From: [REDACTED]
To: [Norfolk Vanguard](#)
Subject: re Preliminary Meeting Norfolk Vanguard
Date: 30 November 2018 15:29:39

Oulton Parish Council

However we would like the opportunity to highlight issues regarding Vattenfall's Norfolk Vanguard (Boreas) projects and its potential cumulative impact with Orsted Hornsea three projects, given their shared access route and impact on residential amenity and local roads.

Cumulative Impact issues:

Figure 1 Location of Old Railway Gatehouse

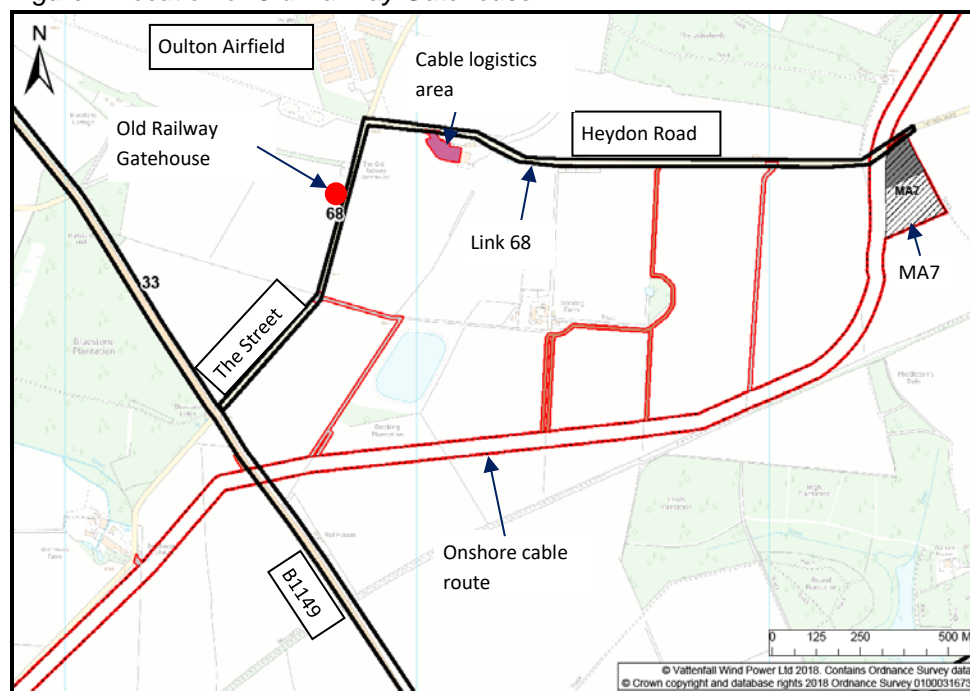
- There is one residential property '**The old Railway Gatehouse**' that will be exposed to the traffic from both projects as the property is located on 'The Street'. The increase in HGV's using the same route from the two projects over an extended period will impact hugely on this property's amenity. There is a need for this property to be assessed in respect of air quality, noise and vibration, and mitigation sought to reduce the cumulative impact.

### OPTION 1: PASSING PLACES

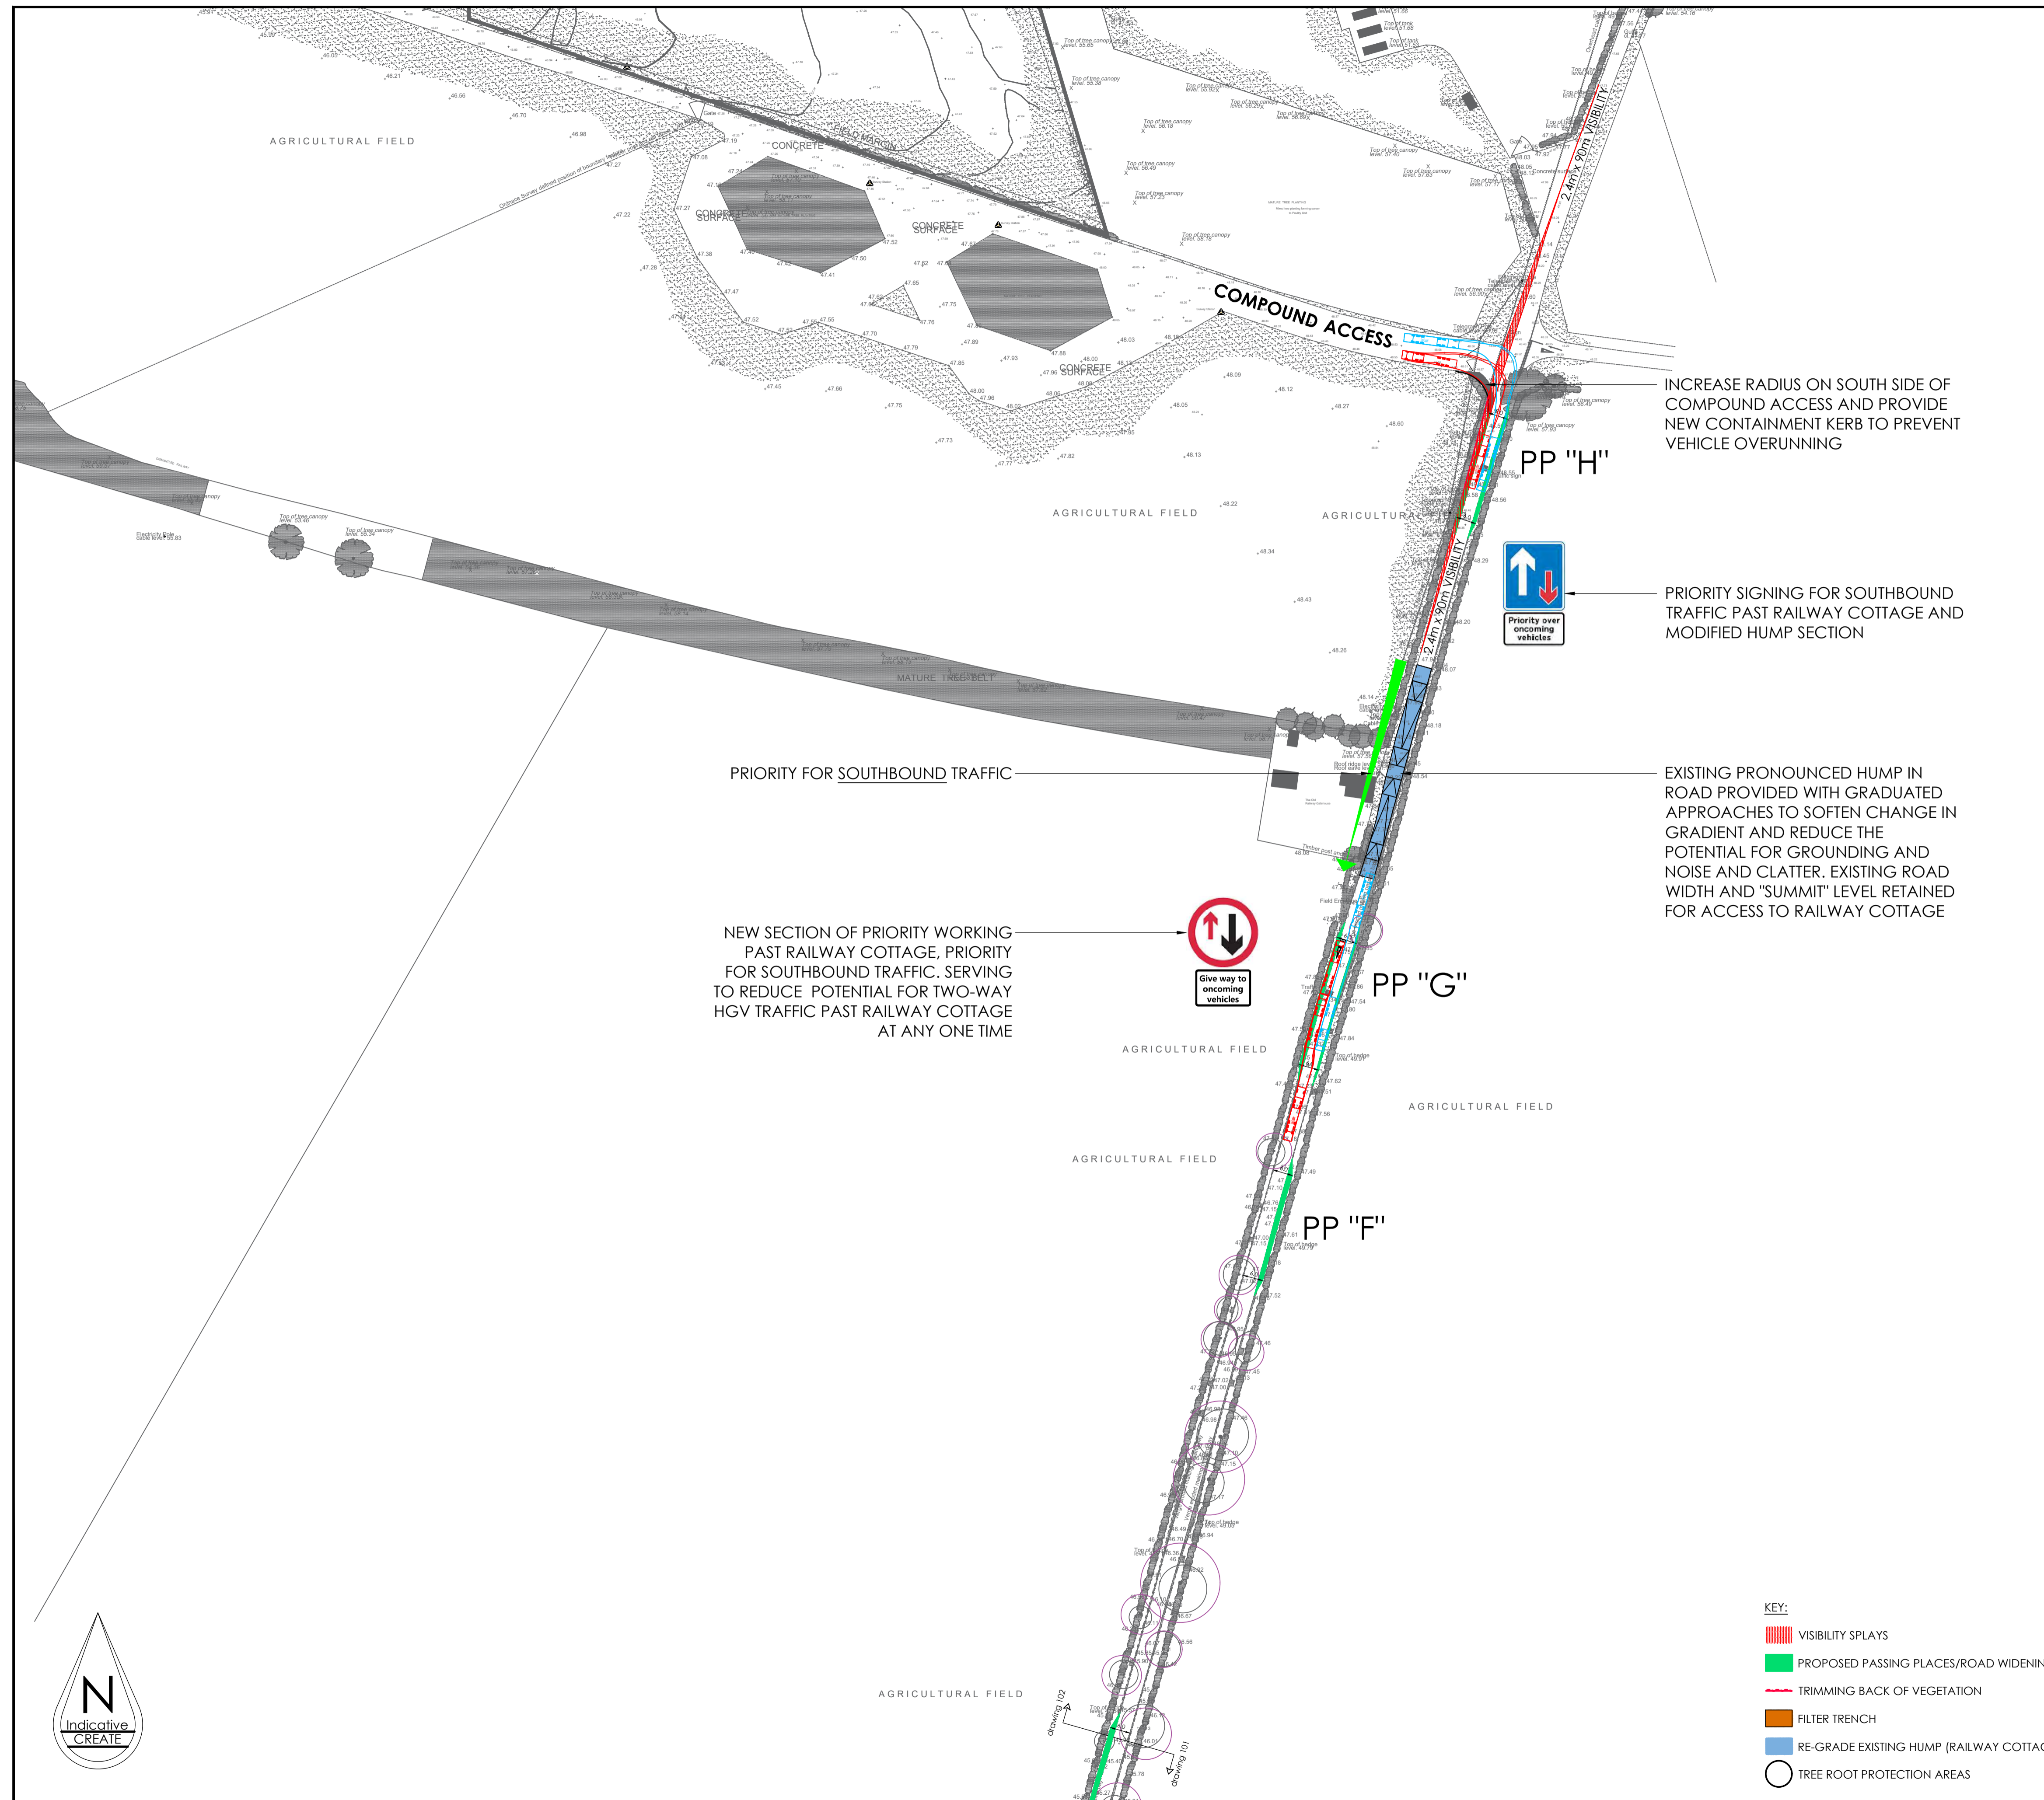
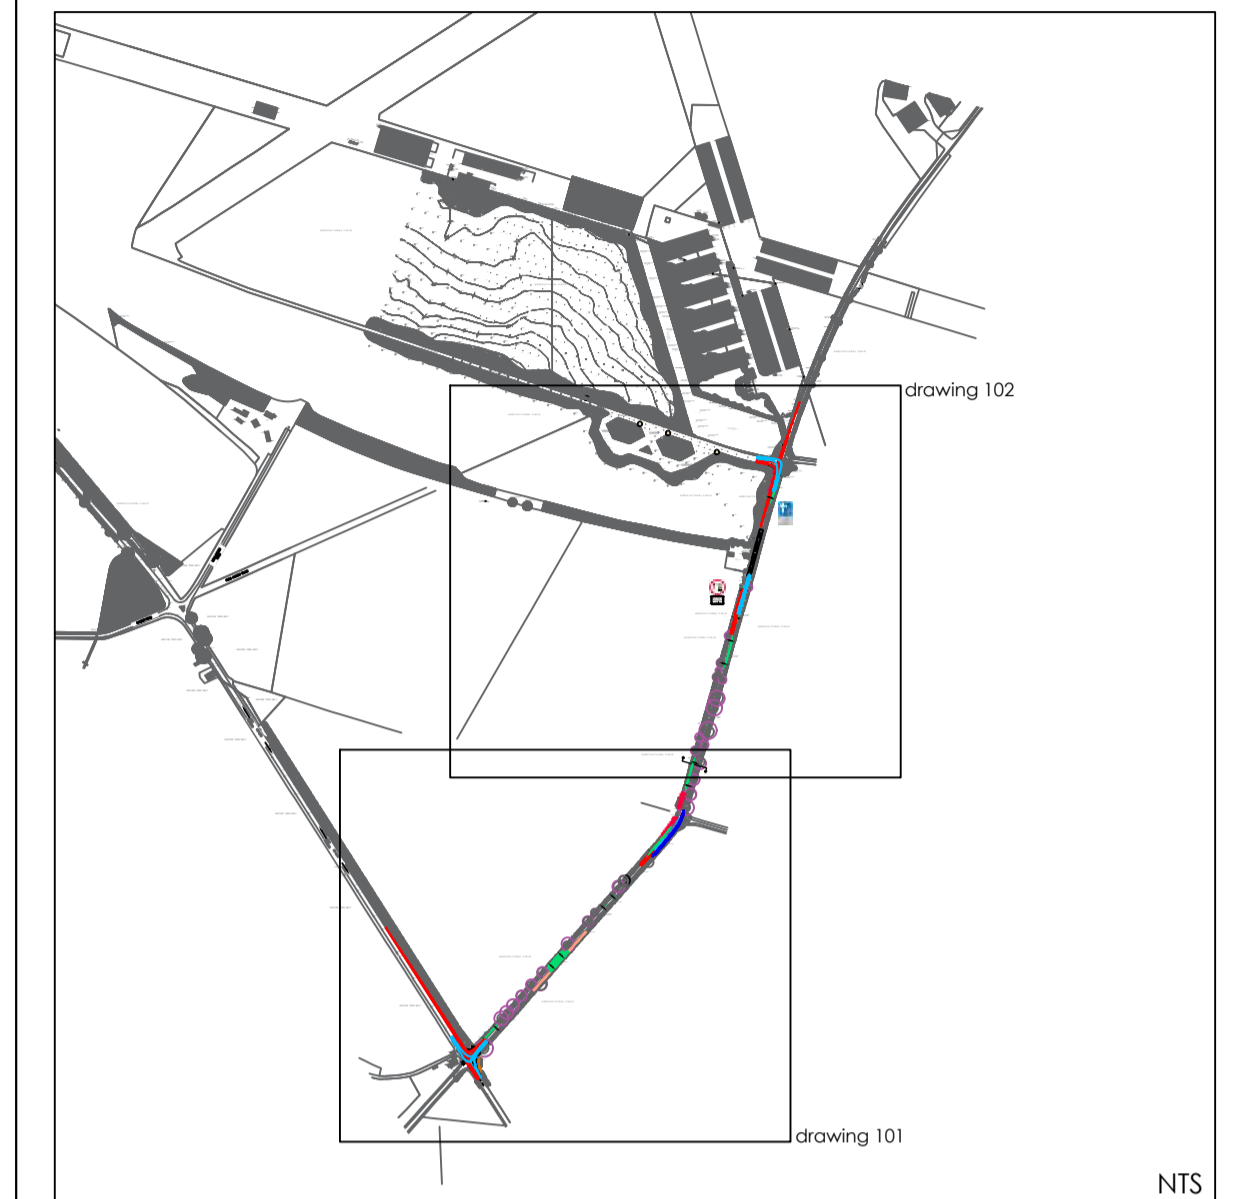
- **Orsted HOW3** proposes to make several changes to the 1km stretch of 'The Street', which is a rural road to be able to accommodate their HGV's; These will consist of a permanent modified road junction at the B1149/The Street with warning signs, extended passing places, widened bend, permanent smoothing of an old railway hump with priority signage.

- **Vattenfall** have not proposed any changes to this access route even though traffic numbers are nearly the same. As far as OPC are aware they haven't carried out any ATC surveys for 'The Street' or carried out a safety audit. OPC would like to know if Vattenfall propose to share Orsted's traffic scheme and costs.

- If Vattenfall propose to operate their own traffic scheme, how will this work with the combined traffic created by the two projects combined with the large numbers of existing agricultural vehicles and other traffic?
